EPC DPW Stormwater-GEC Comments.pdf Markup Summary

PPR2619

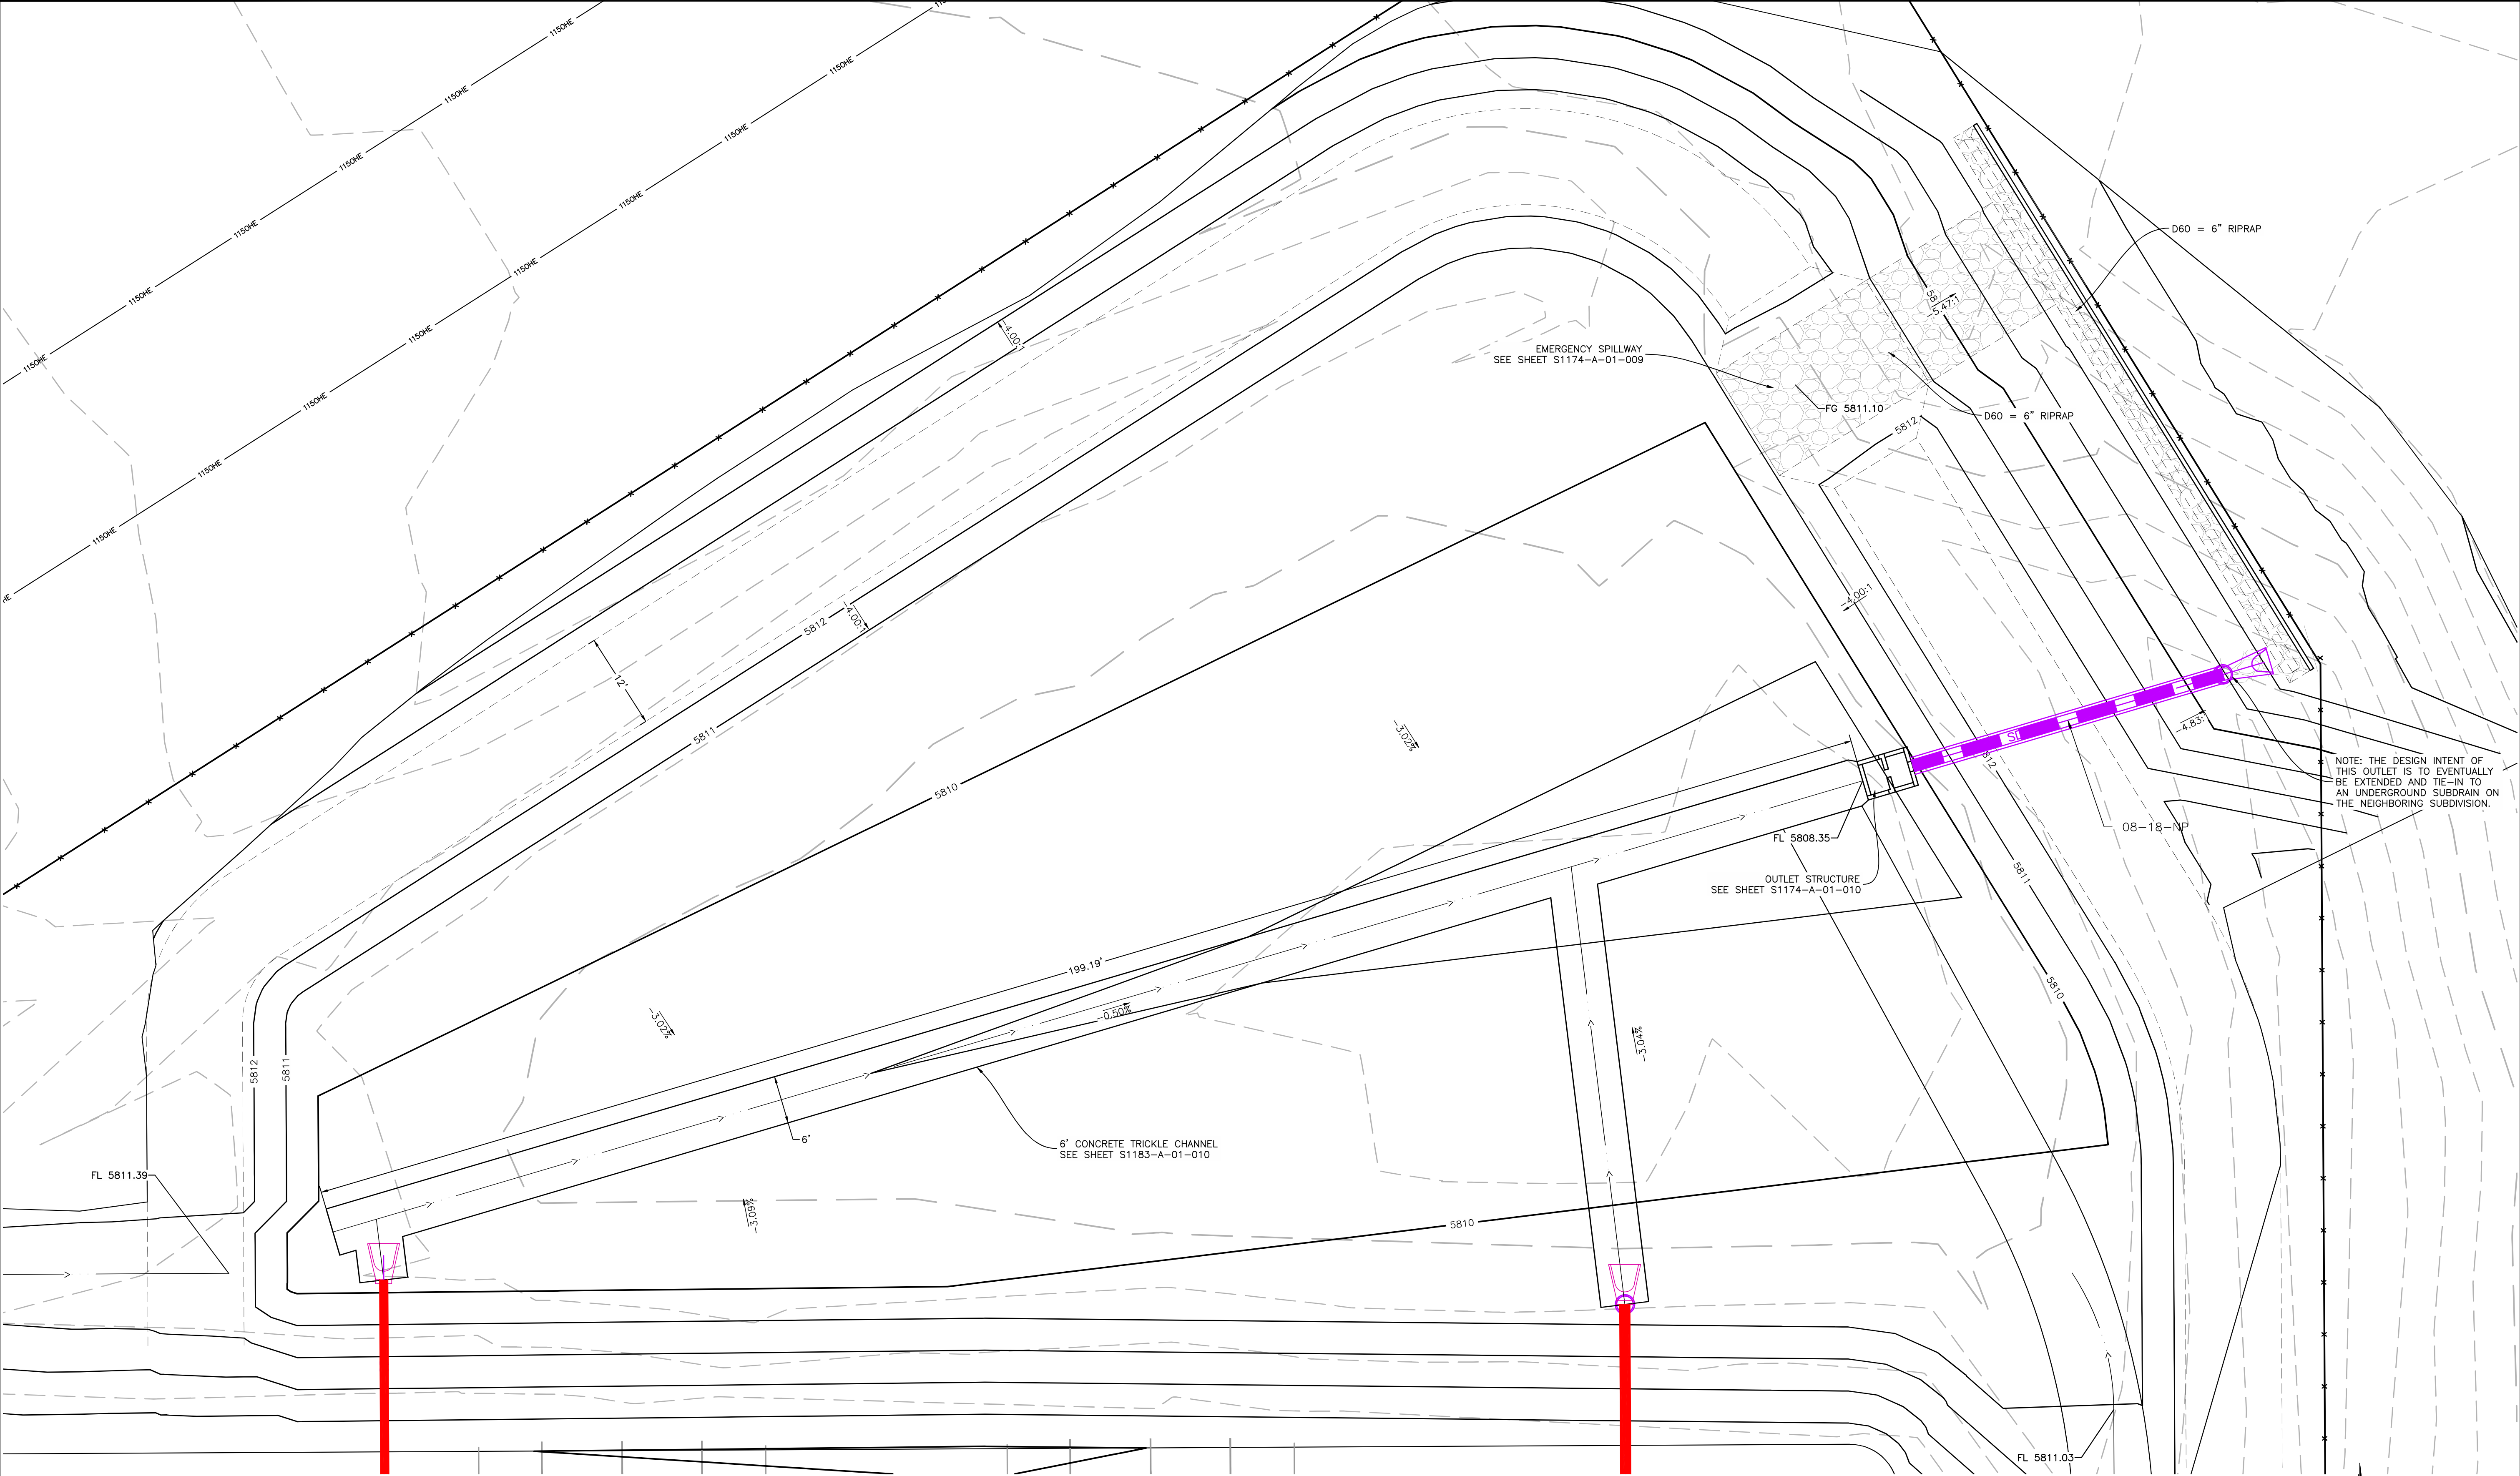
Ensure design calculations are provided for both swales

Provide riprap rundown from end of swale to pond forebay

Add additional contour labels in this area

Show existing site conditions as they are. Before this PPR, there was EGP26XX which includes a roadways, TSB, borrow pit, and temp ditches.

DMC RESPONSE: Swales have been modeled in SSA (SWMM) to verify sufficient capacity. Reference drainage report.

DMC RESPONSE: Rip rap rundown added, no fore bays included as discussed in drainage report.

DMC RESPONSE: Contours labeled

DMC RESPONSE: As discussed with EPC, Roadways, borrow pits and temp ditches outside of this property are being maintained by others and are not part of this project. Existing TSB outlet pipe is now shown.
